CITY OF ALBUQUERQUE

July 3, 2019

**Re: Murphy Express, Wyoming
1358 Wyoming Blvd NE
30-Day Temporary Certificate of Occupancy
Transportation Development Final Inspection
Engineer's/Architect's Stamp dated 11-3-17 (J20D037)
Certification dated 7-2-19**

MURPHY EXPRESS
ALLEY IMPROVEMENTS

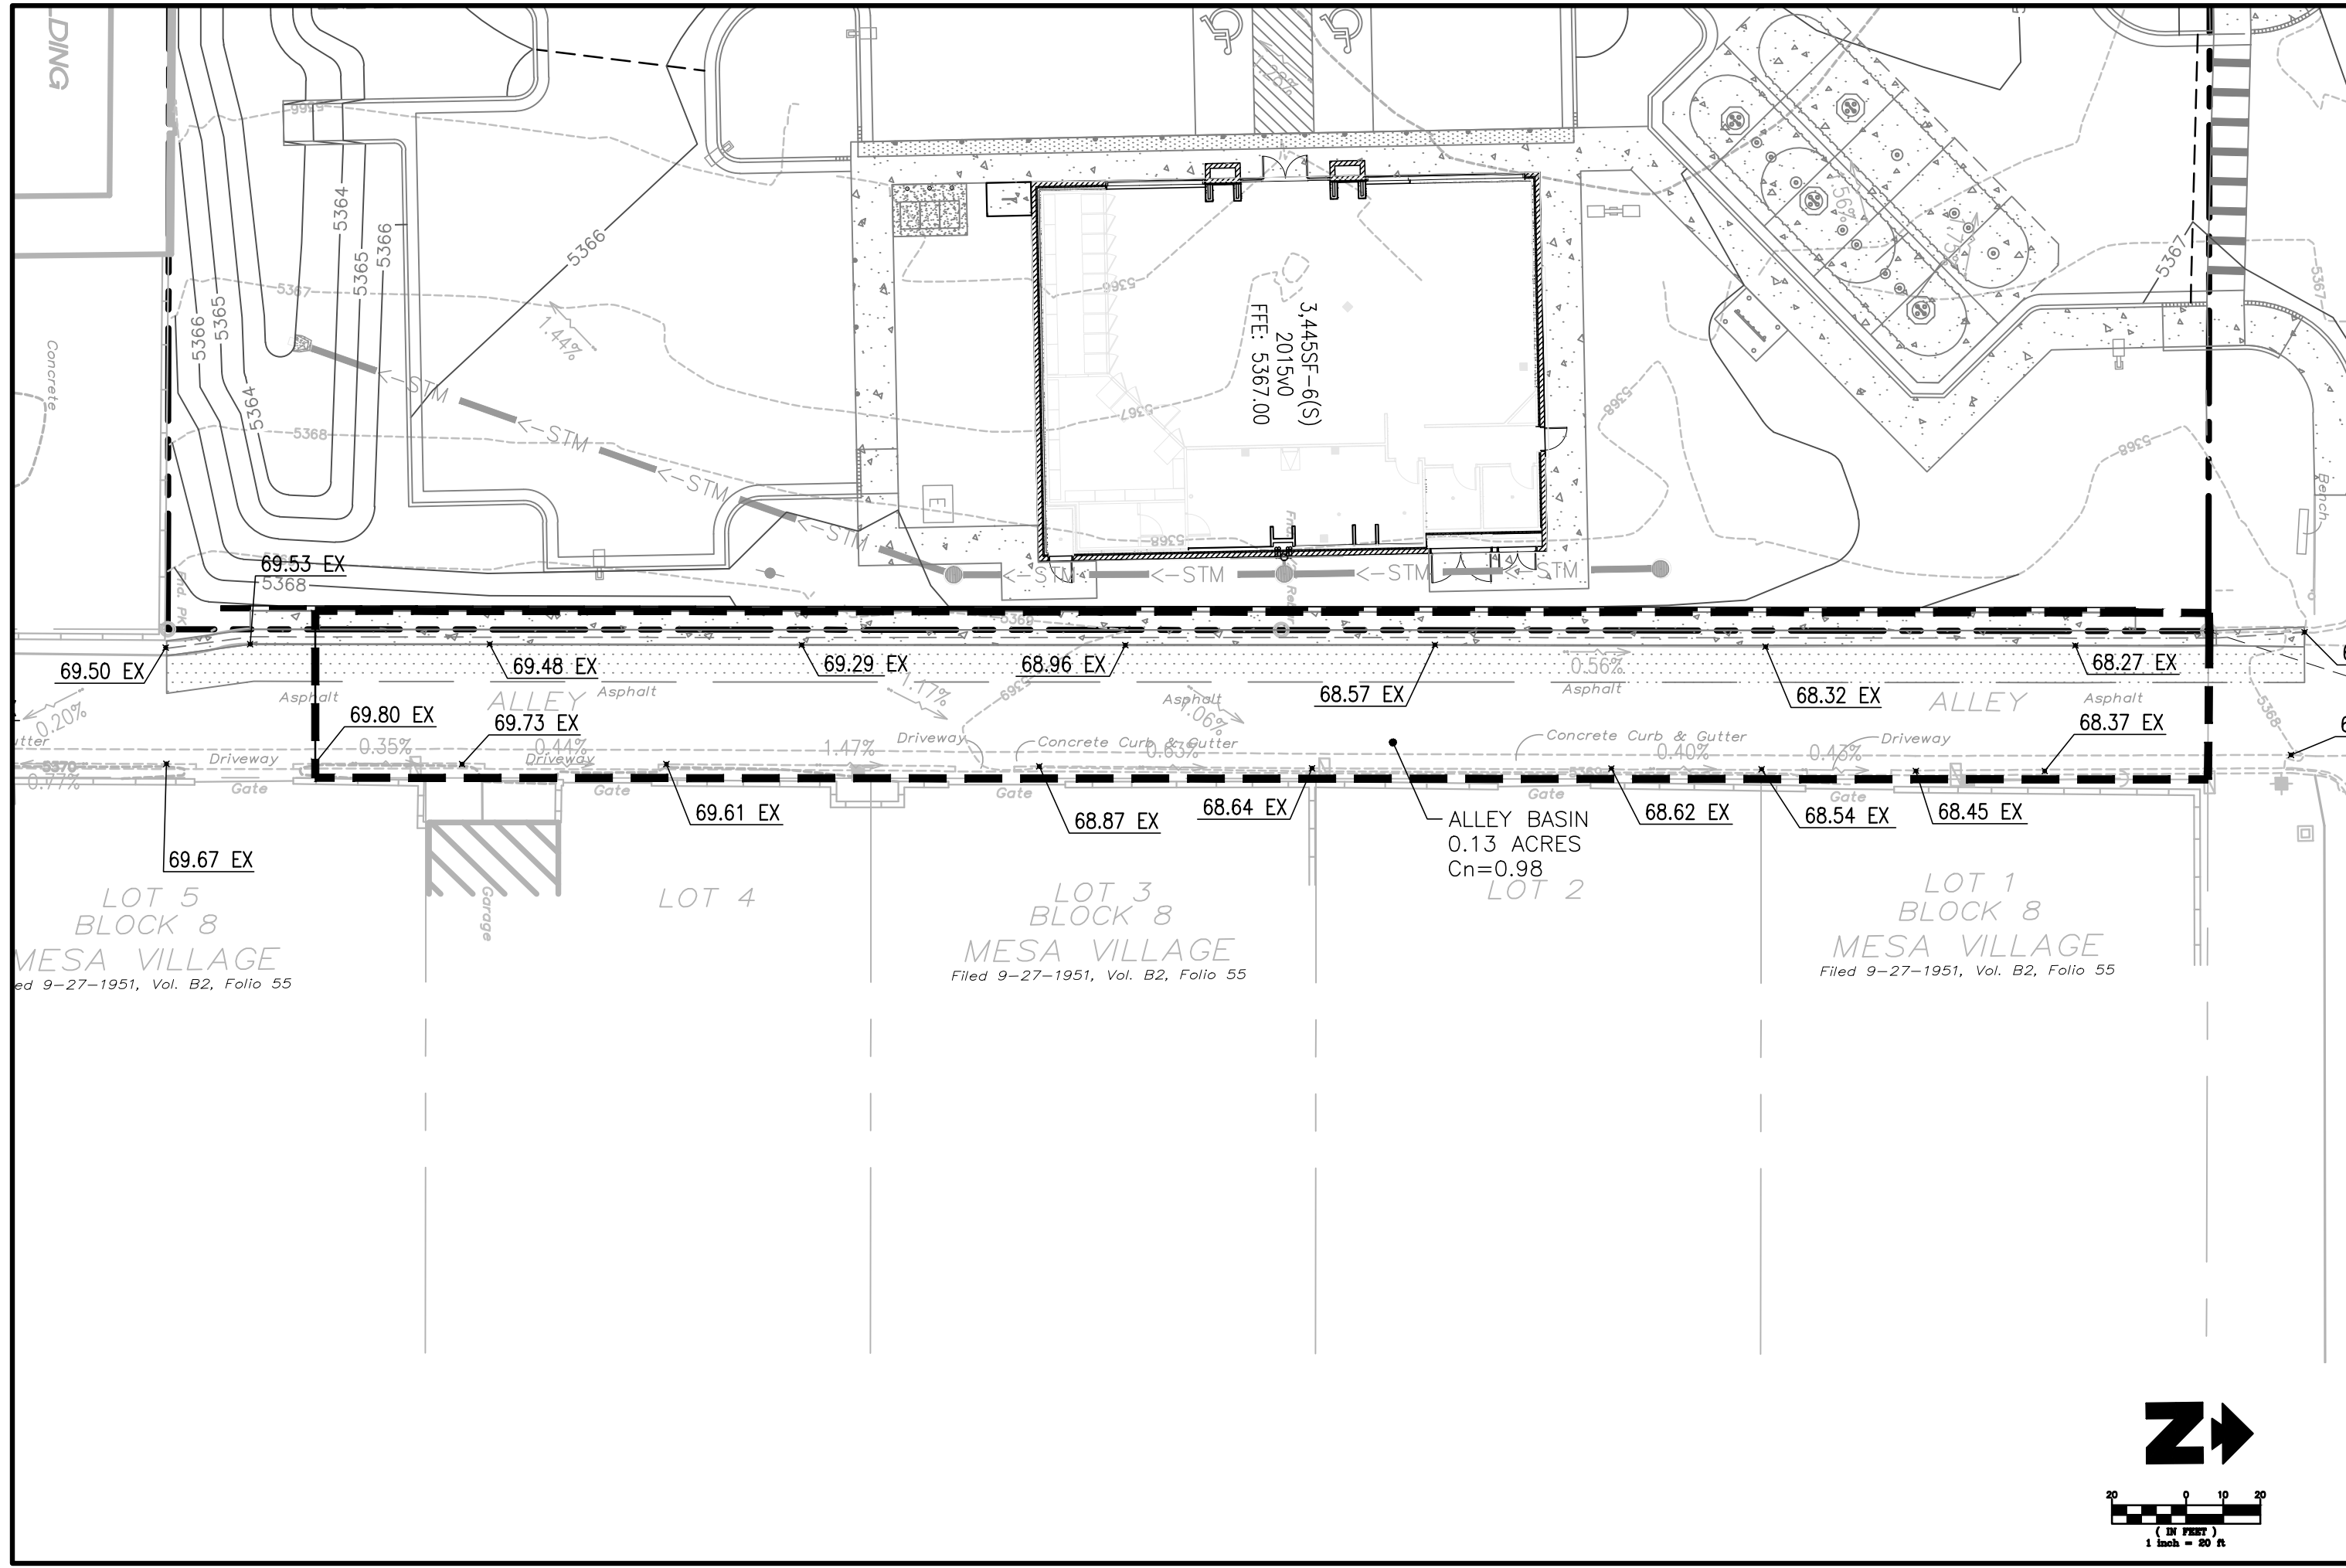
1. Please complete Alley Paving.
2. Please add Truncated Domes to access of Wyoming.
